Figure 13 – Proposed publicly accessible link

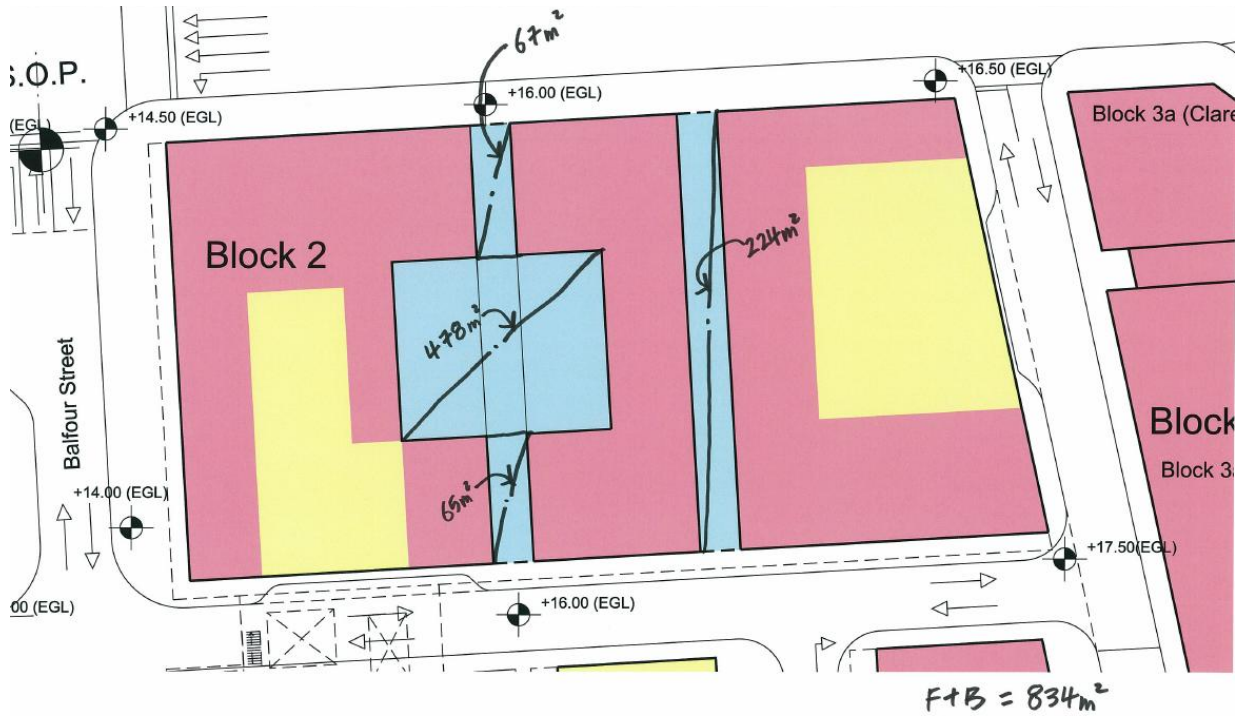
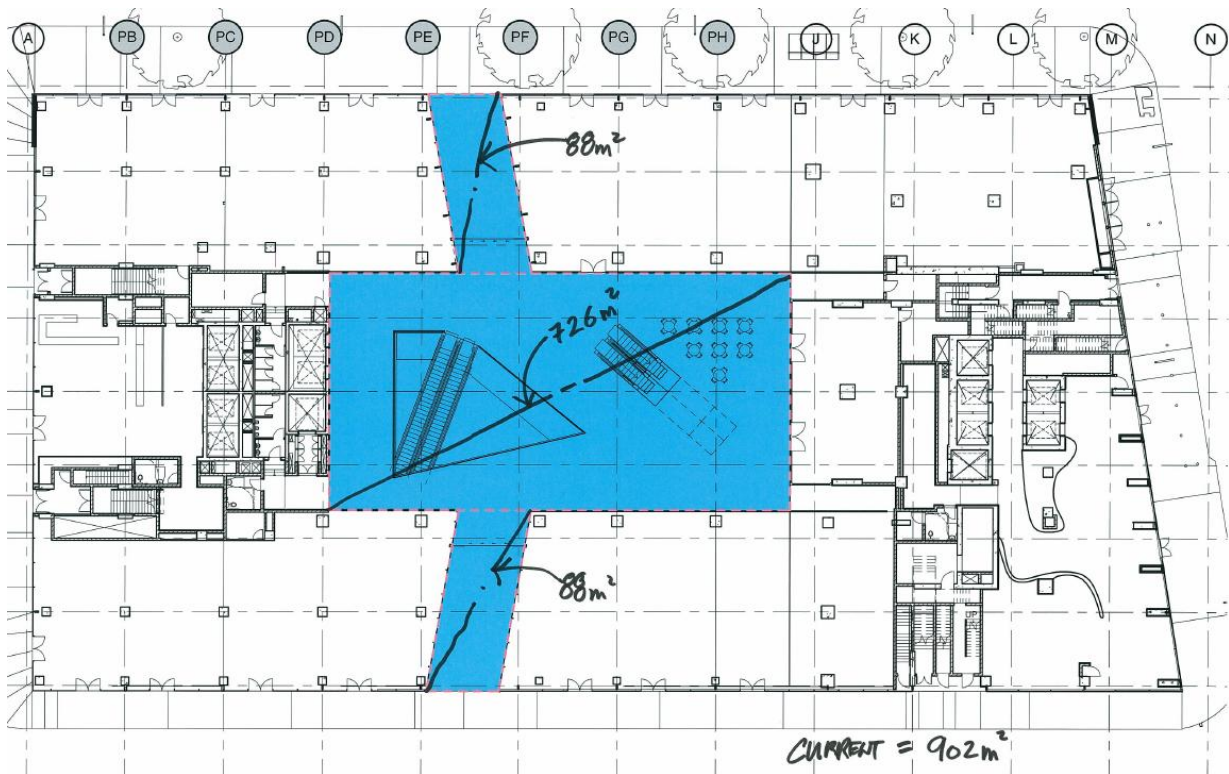
Council has stated the reasons for their objection are the escalators down to the Lower Ground level and the supermarket because they ;

(a) obstruct the link visually

(b) reduce the success of the link as a permeable path for pedestrians

- this is incorrect as they are traveling down and people can see across the void to the arcade entry opposite,
- escalator handrails etc are glazed and below line of sight
- vegetation from the wall adjacent the escalators from Lower Ground will be low and not obstruct the sight lines

- pedestrians can easily see the route around either side of the Lower Ground escalator void to the egress/ entry opposite and such diversion is minor when considering their total route (see pick dotted alignment compared to green path via lower ground or blue via ground floor on the attached),

- Council is ignoring the potential pedestrian path via the Lower Ground which over-all is shorter than that on grade and would be an important link for most pedestrians (refer to green highlighted path on the attached)

- This mid block link provides pedestrians with an alternate route other than using Kent Road or Balfour Street to access from Broadway to the internal areas of the site. It should be acknowledged that people will use this route because of the adjacent retail activities, better visual experience from the arcade and atrium with its glazed roof together with a safer environment away for traffic noise etc

- The design has been adopted to avoid the direct route to help reduce any possible wind induced into the atrium via a straight link
- The design intent is to make the transition through the site link as visually pleasing as possible without causing too much interruption to the normal course

- The link as designed offers people choice as they move through the site link to explore other destinations again without causing too much interruption to the site link.
